Our ref: L.A11230.003.StPhilipsCC-RTS.docx

25 October 2022

RE: RESPONSE TO SUBMISSION - ST PHILIP'S CHRISTIAN COLLEGE, CESSNOCK SSDA

Table 1.1 Response to Submission

Annex B: Pre-development Flood Maps

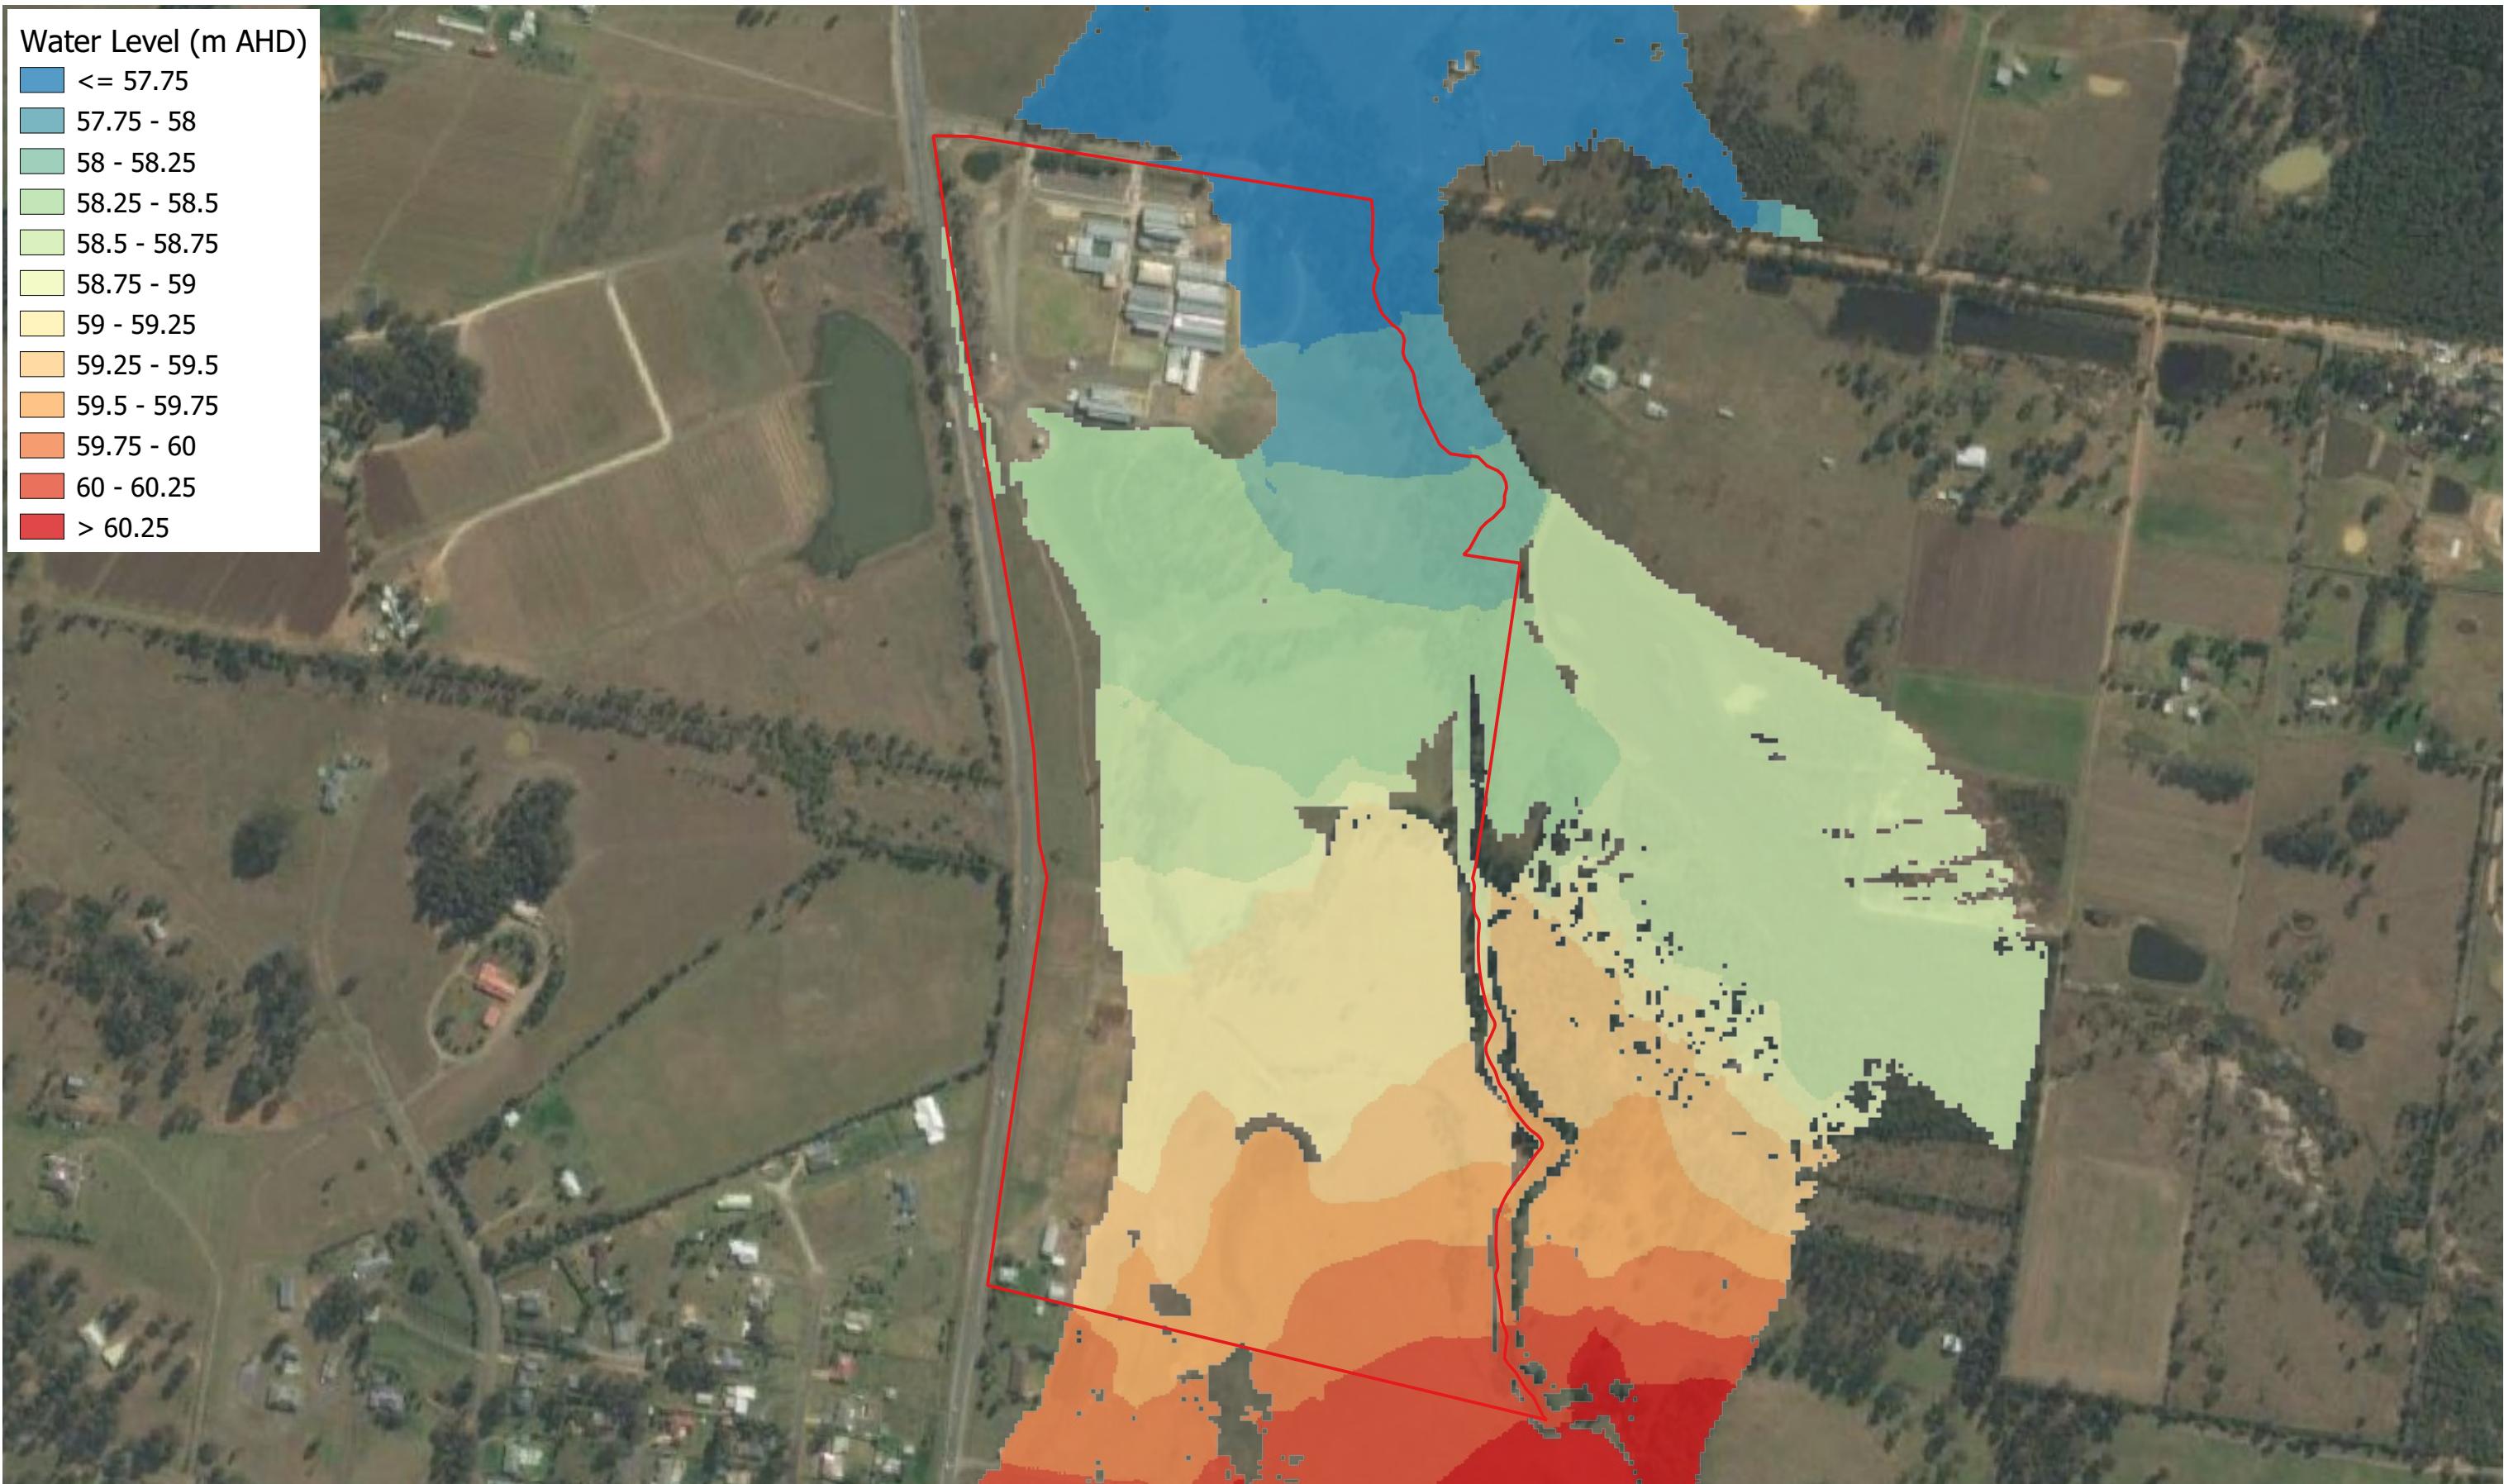
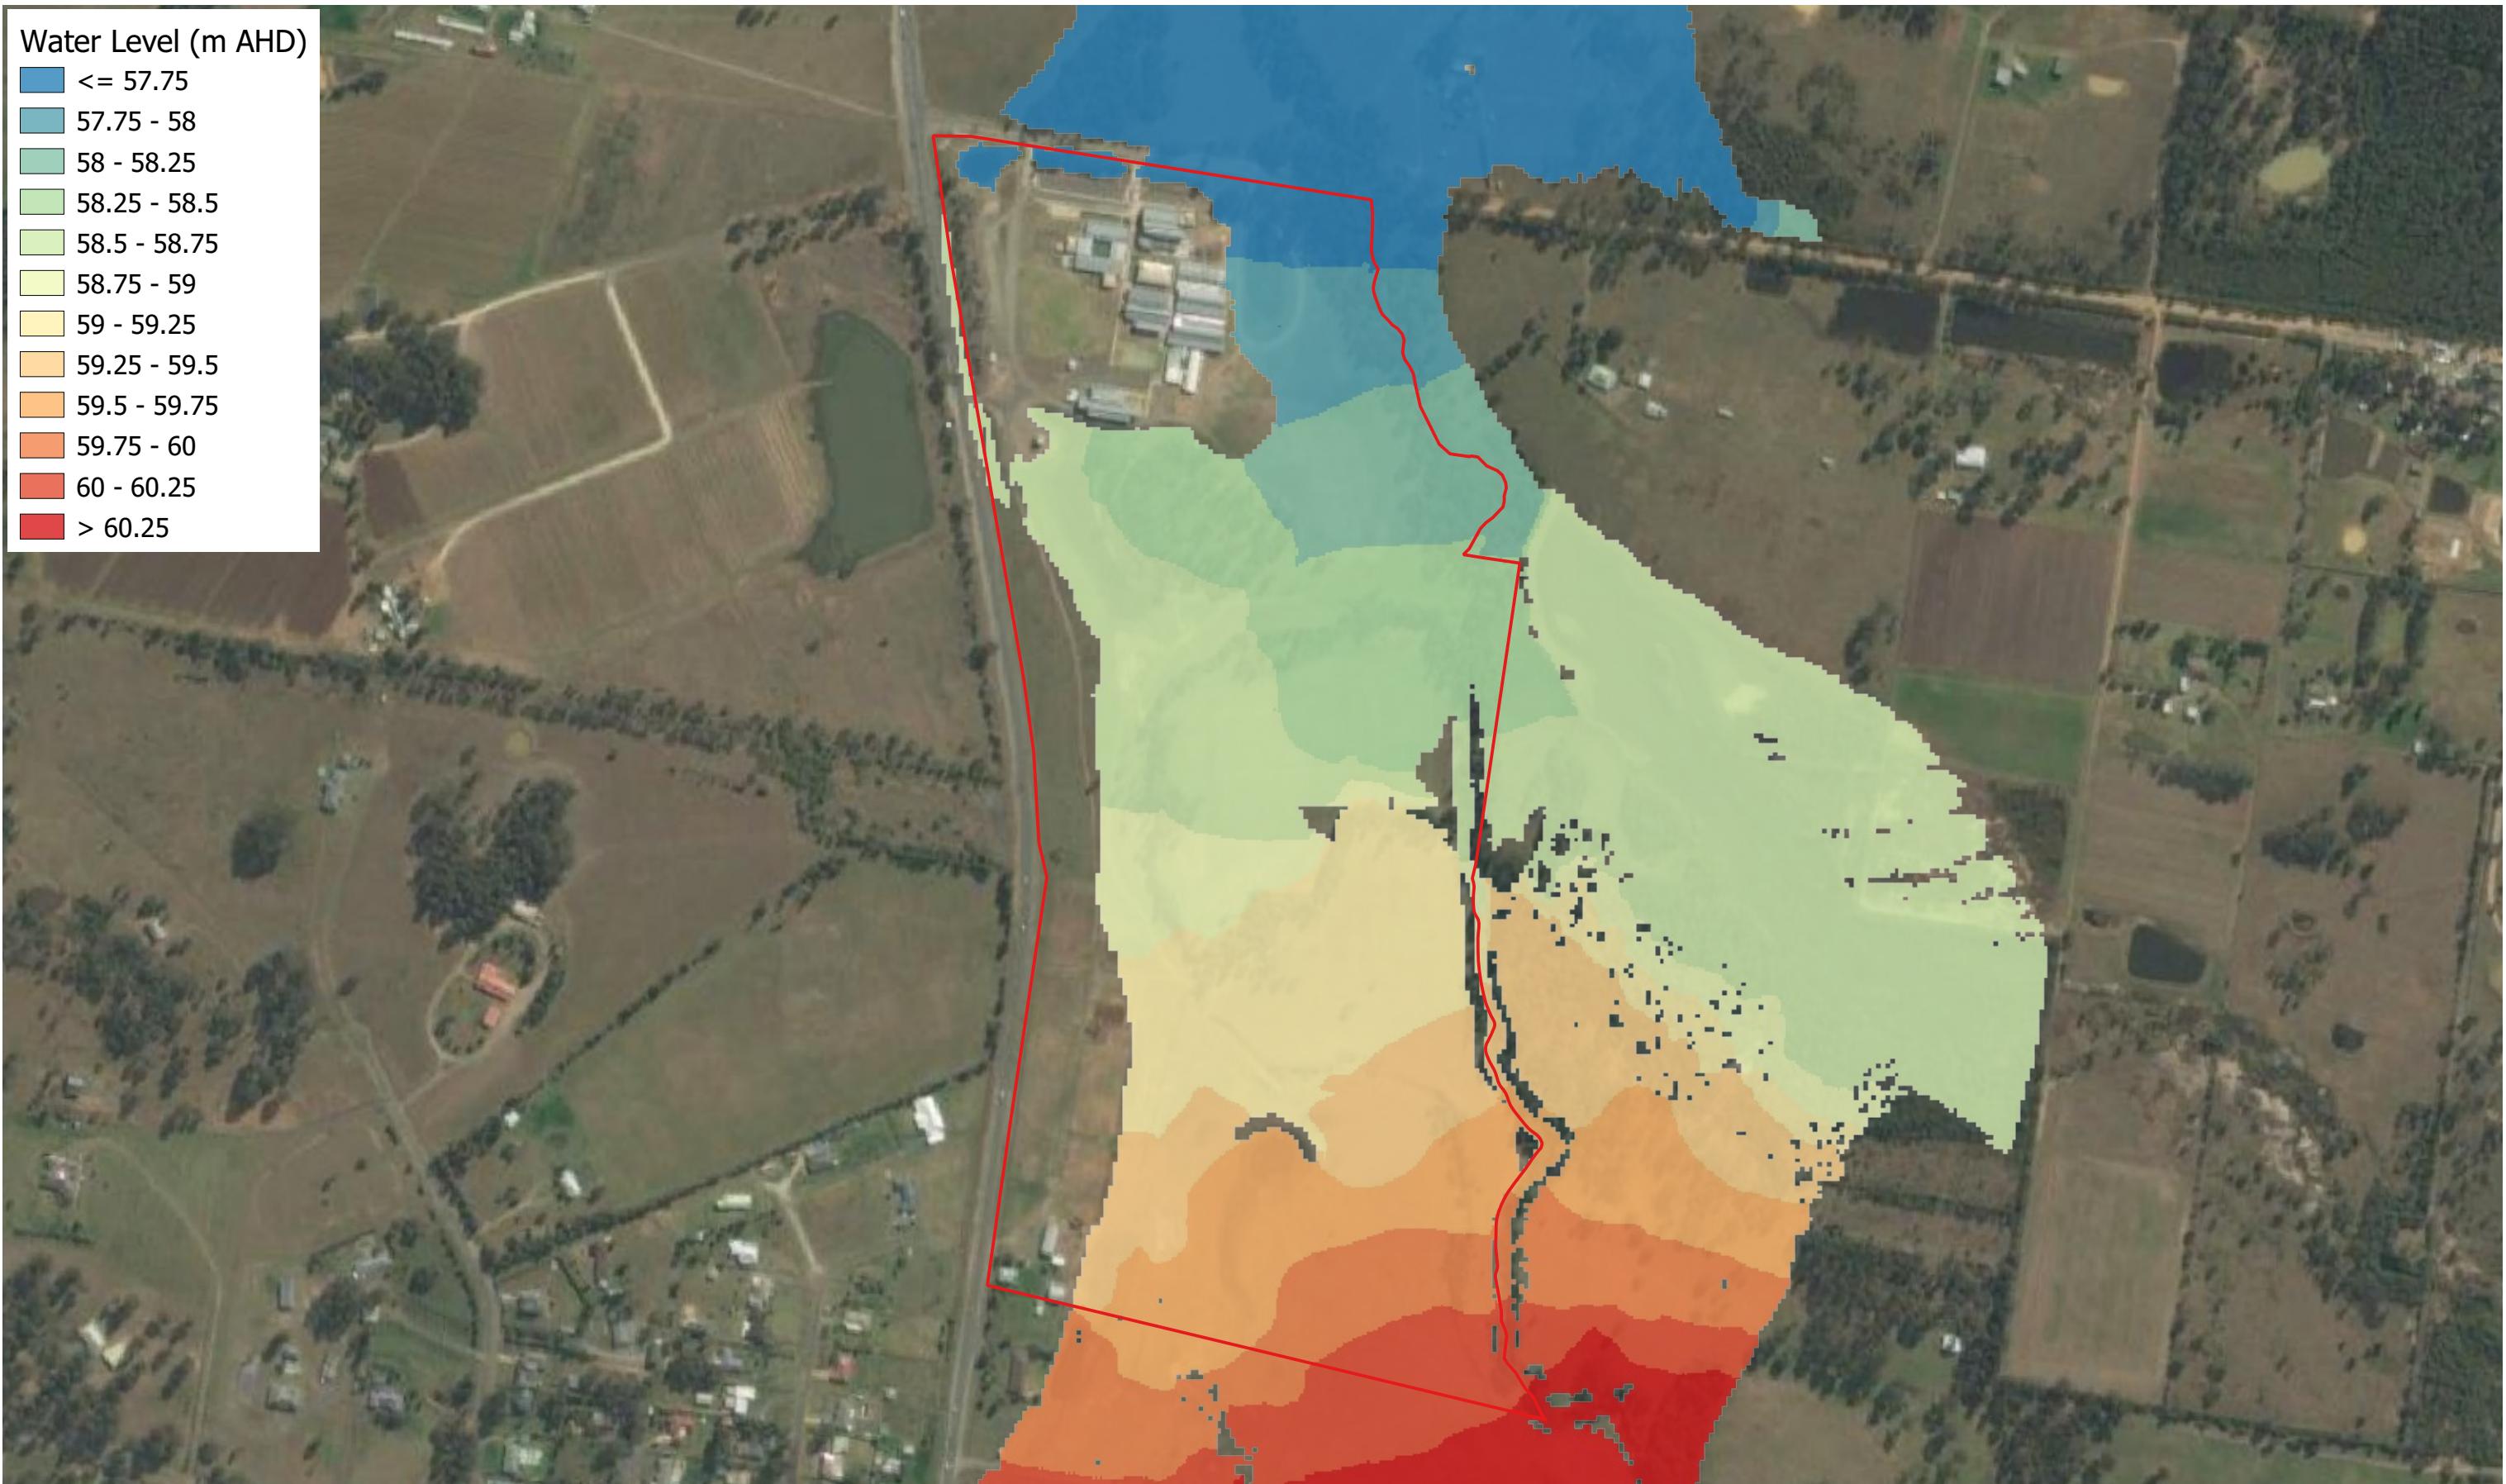
• <i>Distribution of flood water is shown to increase between 20-50mm along the eastern boundary to Lot 892 DP 574957.</i>	Whilst offsite flood impact due to the proposed development is predicted to occur for the 2% AEP event and above, the peak flood level increase beyond the acceptable 20mm threshold is marginal (which occurs in area subject to typical peak flood depth in excess of 1m) and the impacted extent is confined within the Black Creek corridor (negligible change in encroachment). Neither the existing residential building within the neighbouring lot (Lot 892 DP 574957) is affected nor the flood hazard of the impacted area is significantly altered (hence minimal change to existing flood risk).
<u>Department of Planning and Environment</u>
